Consultation Response from: KC Environmental Health (Pollution & Noise Control)
2025/90517 - Land off Forge Lane, Thornhill Lees, Dewsbury, WF12
Outline application, including the consideration of access and layout, for two commercial units (use class B2 and/or B8) and associated works
**Responding Date:
15 July 2025**
**Responding Officer:
Mohammed Nasim**
**Responding Ref:
WK202519613**
Comments
Air Quality

**Figure 2: Site Layout**

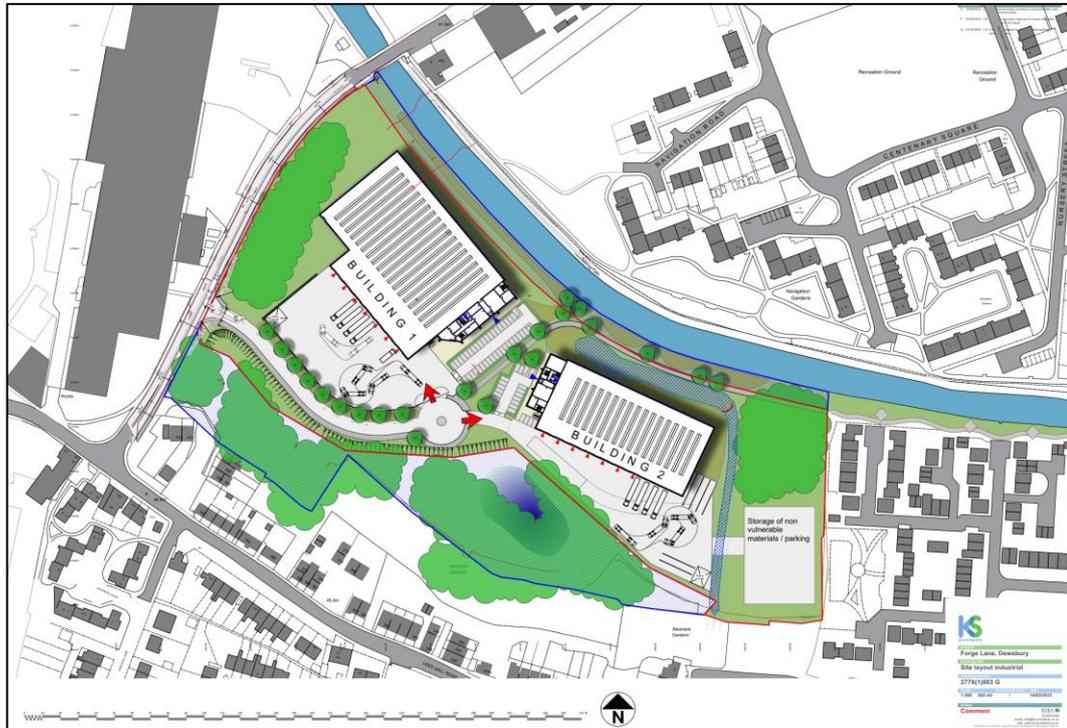
There are no details on the proposed use nor the construction and so modelling has been conducted based upon the details within figure 7. We note there is no key to show the respective wall numbering on the plan in figure 2. Library data has been used for typical HGV operations and uses as shown in table 3 and modelling has been conducted for both unmitigated and mitigated scenarios as shown in the figures within section 4 relating to façade levels at the nearest noise sensitive receptors (NSRs).
